FORMAL COMMUNITY SUBMISSION OF OBJECTION

Application Ref: Mixed Use Development (with In-fill Affordable Housing) – 138 Maroubra Road (SSD-81426710)

Impacted Stakeholders: Adjoining Residents and Senior Citizens of the Maroubra Pacific Square Precinct

DRAWN BY	SCALE	SHEET SIZE	PRINT DATE
Author	1:100	A1	18/09/2025
DESCRIPTION			5:13:25 PM
SOUTH ELEVATION			
PROJECT No	DRAWING No	REVISION	
21_435	DA2.202	N

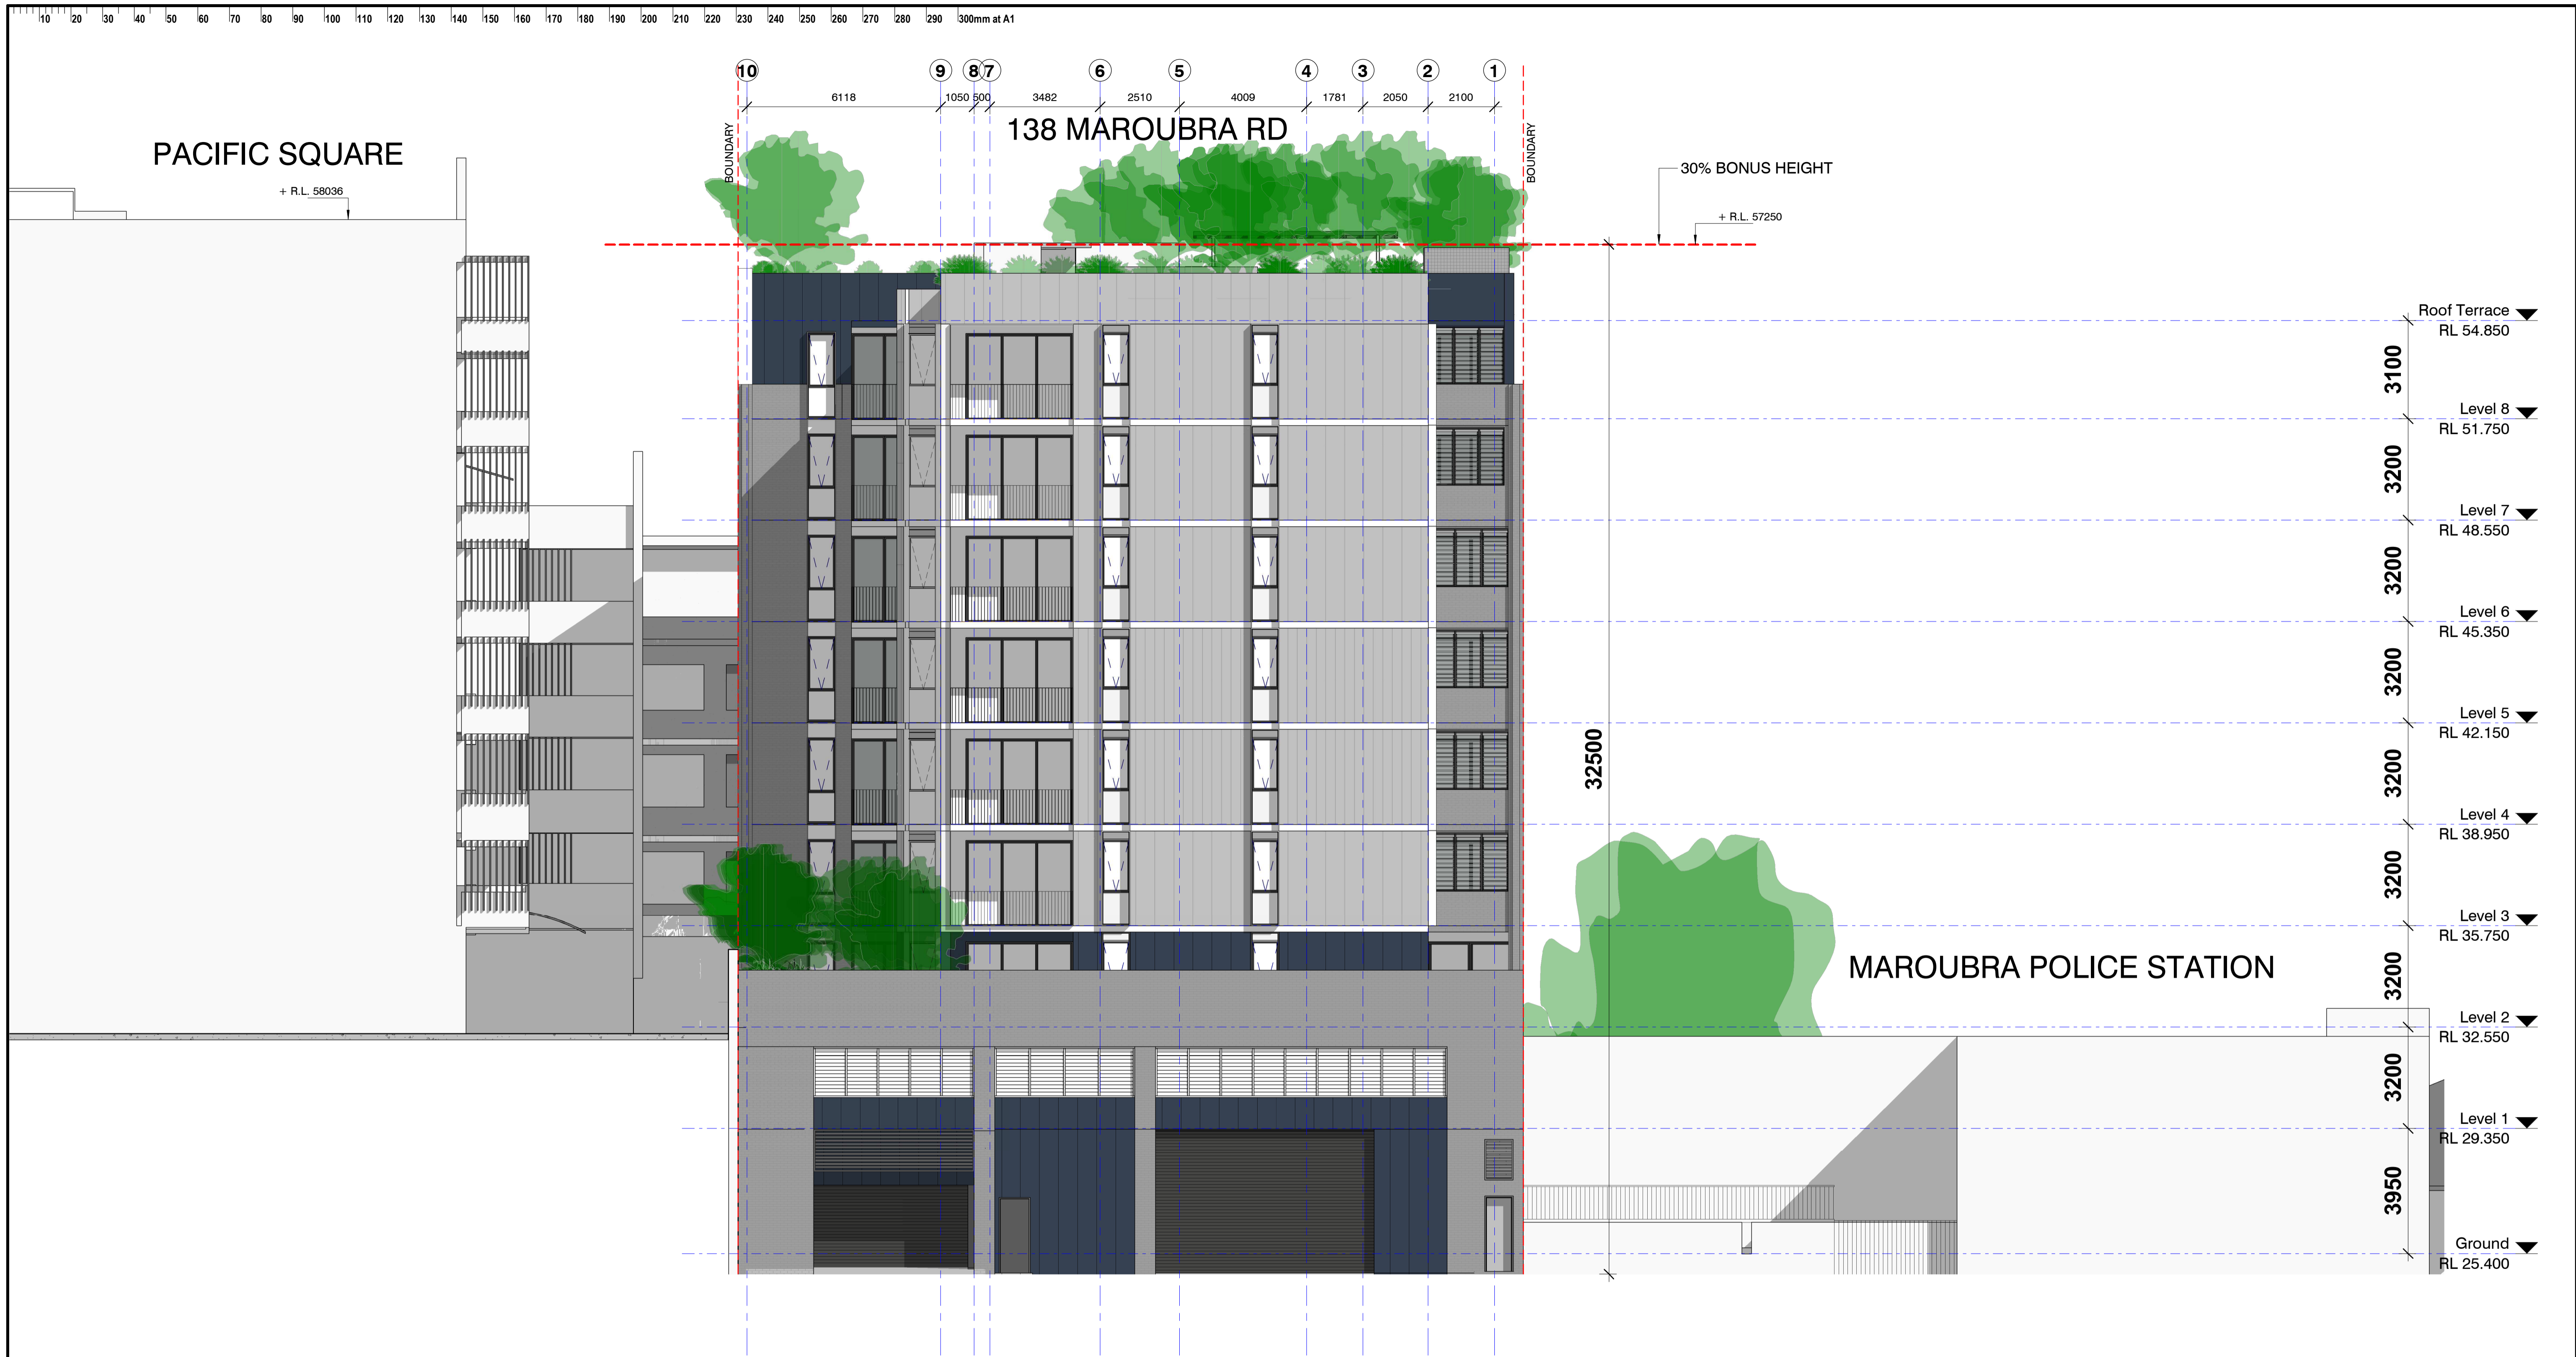
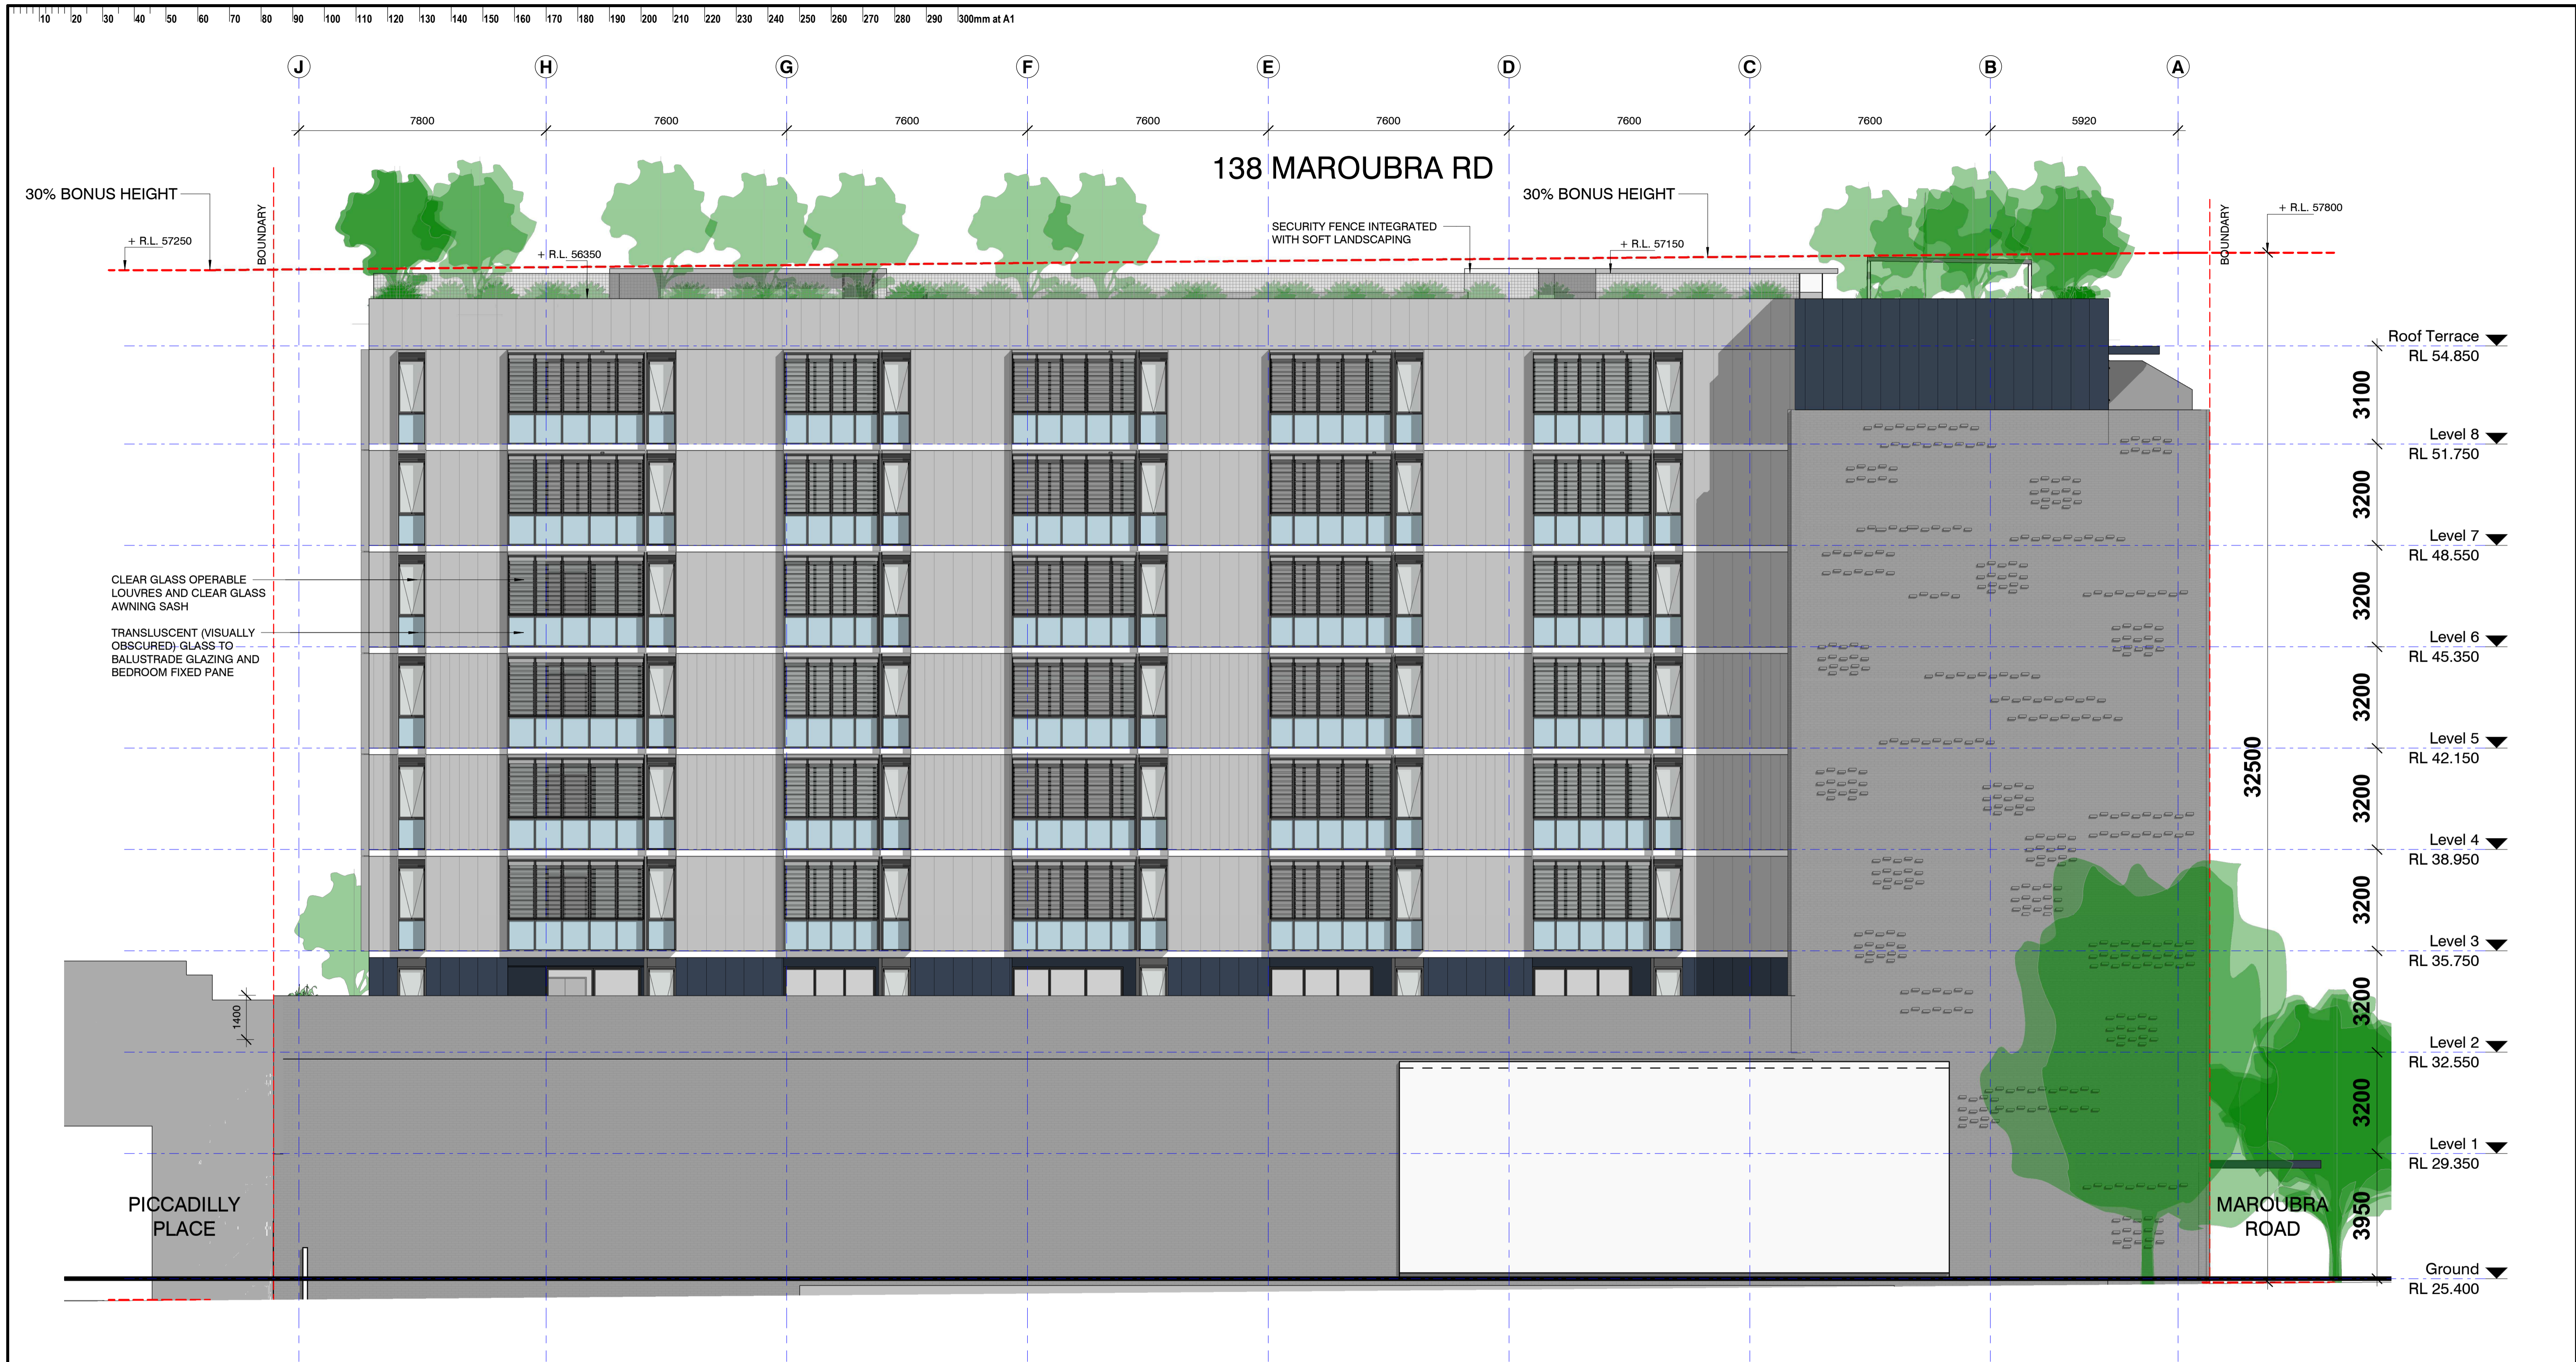
By building a continuous 32.5-meter vertical massing right up against the shared eastern boundary, the proposal places a monolithic 10-storey concrete wall directly outside the windows of long-term elderly residents. Many of these seniors spend the vast majority of their time at home. Forcing direct, permanent visual claustrophobia onto these apartments compromises mental well-being and active living conditions without providing any stepped architectural relief.
